# CITY OF ALBUQUERQUE

December 28, 2023

**Re: Imperial Inn Renovation**  
**701 Central Ave. NE**  
**30-Day Temporary Certificate of Occupancy**  
**Transportation Development Final Inspection**  
Architect's Stamp dated 08-24-22 (K14-D226)  
Certification dated 12-22-23

AS-103-2

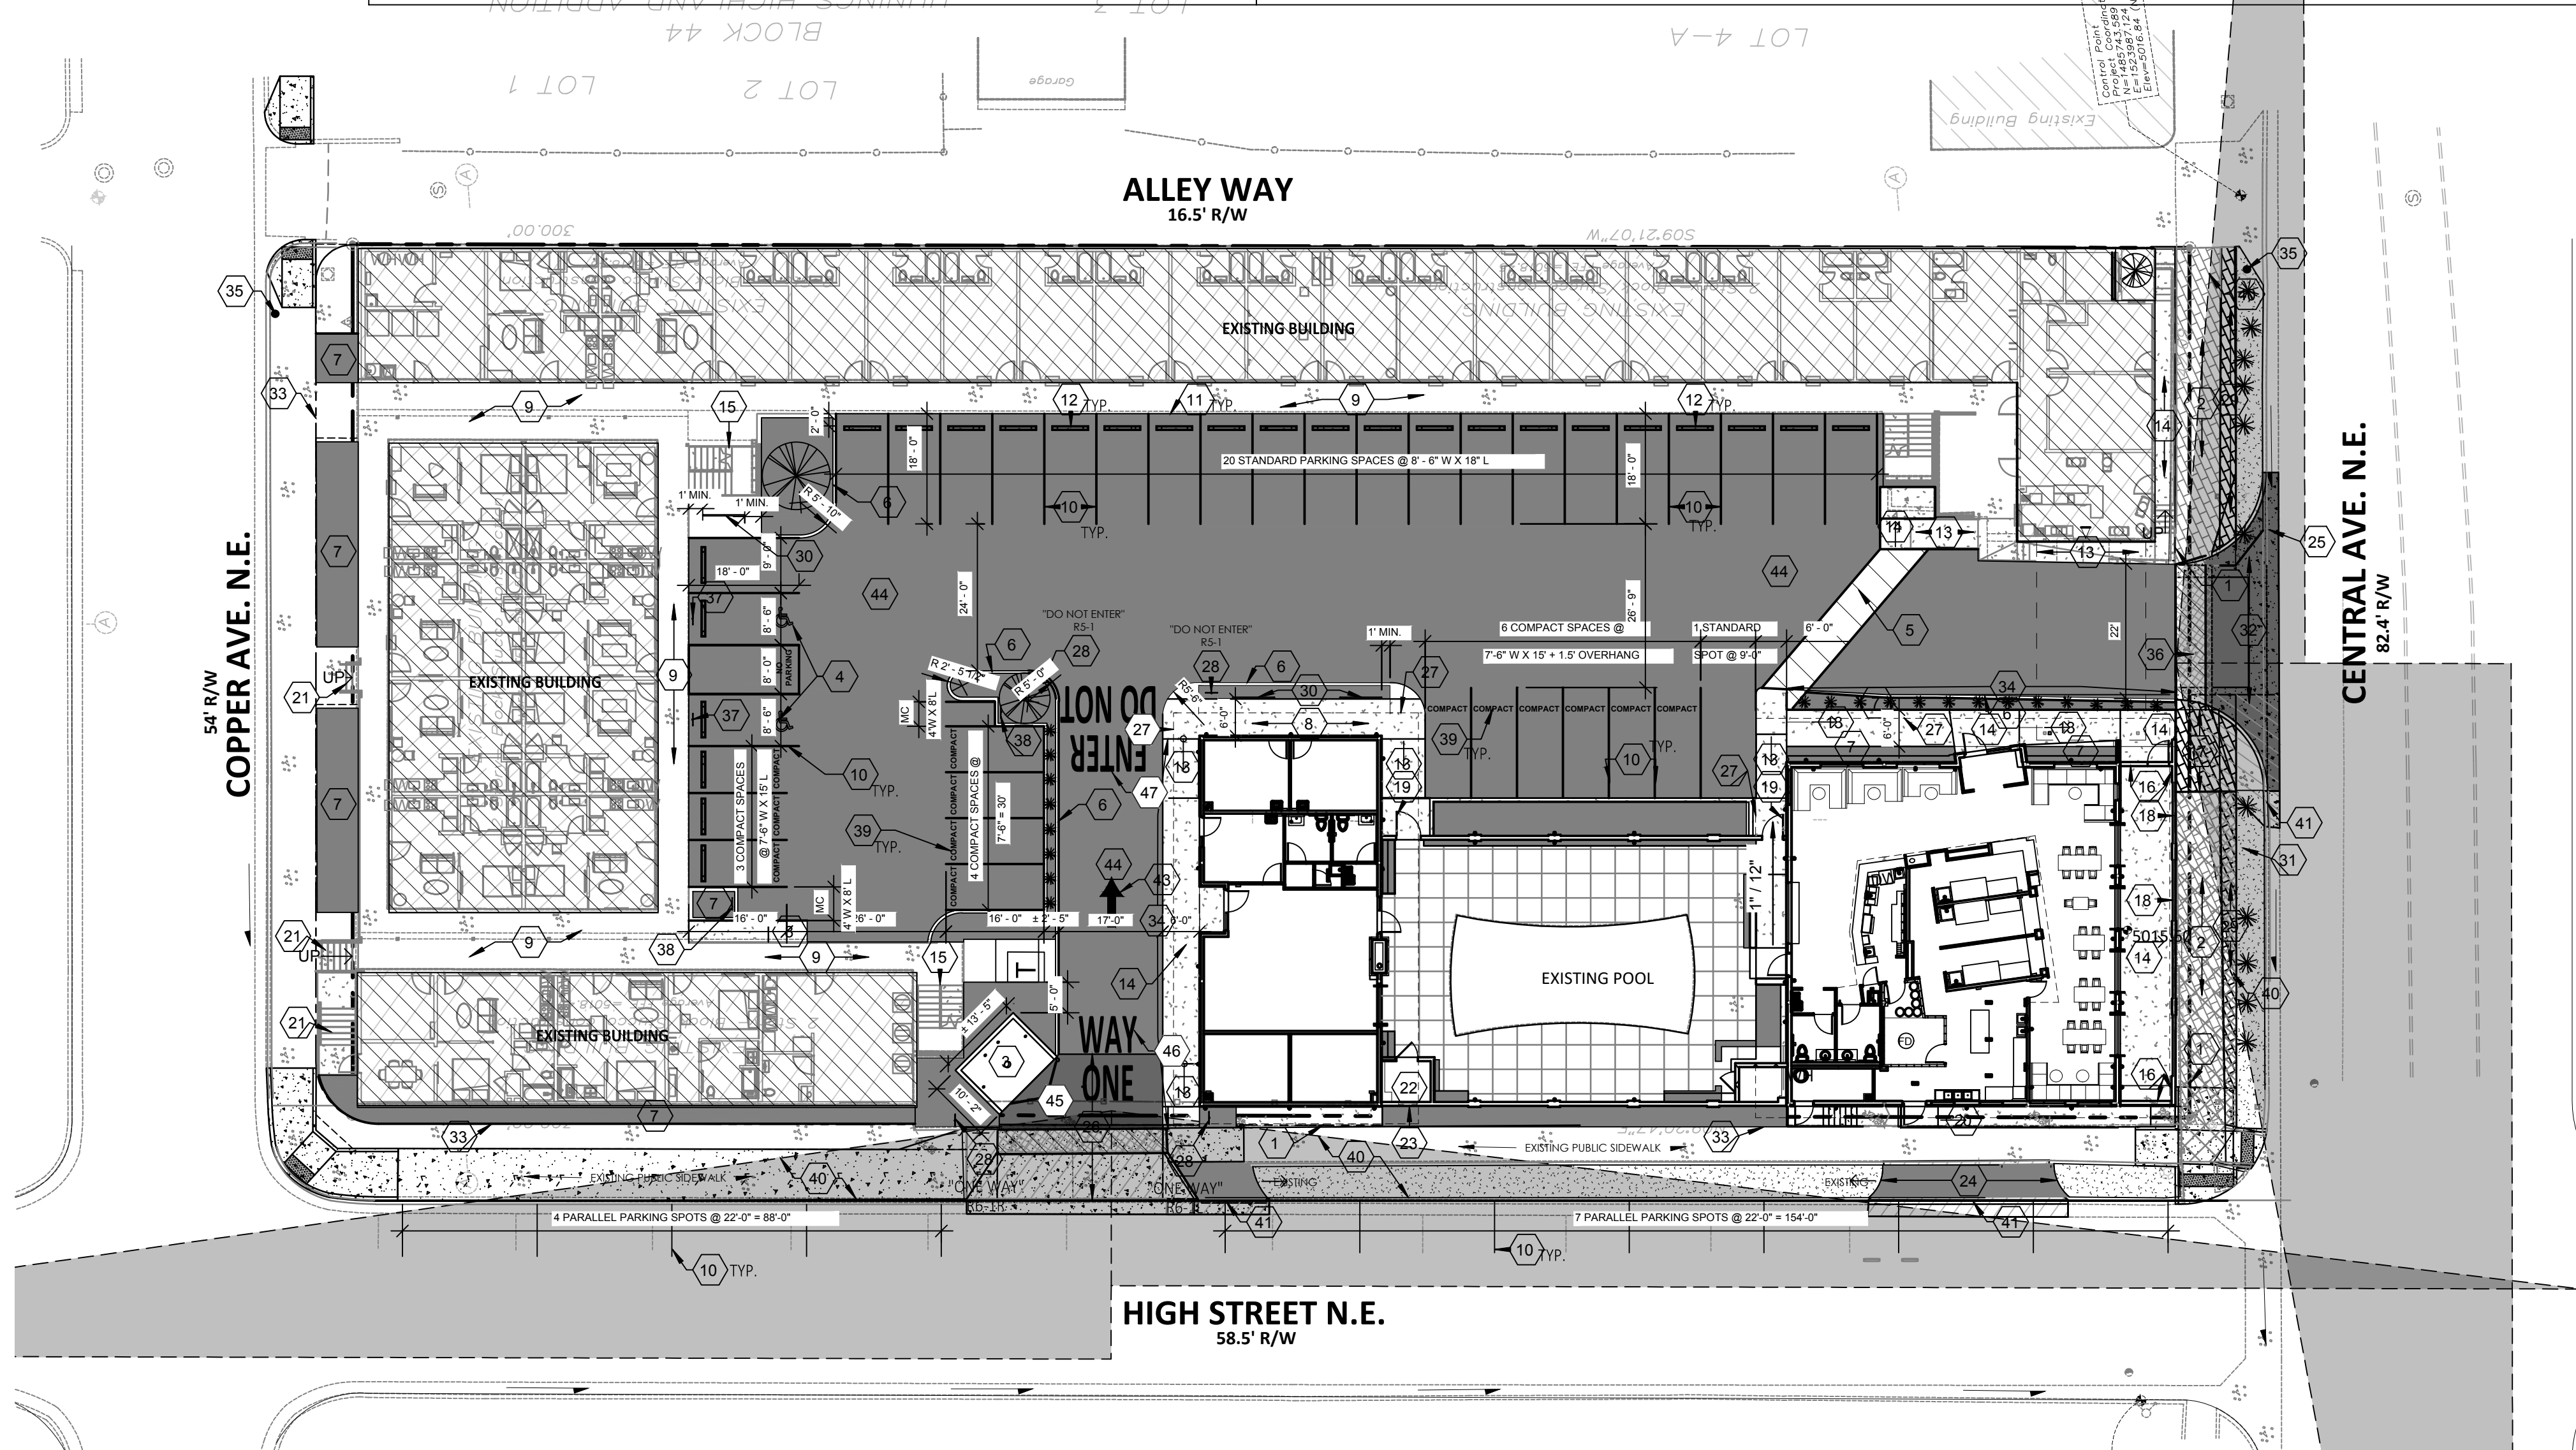
- Per the approved site plan: Install bike racks for the designated number of bicycle parking spaces.
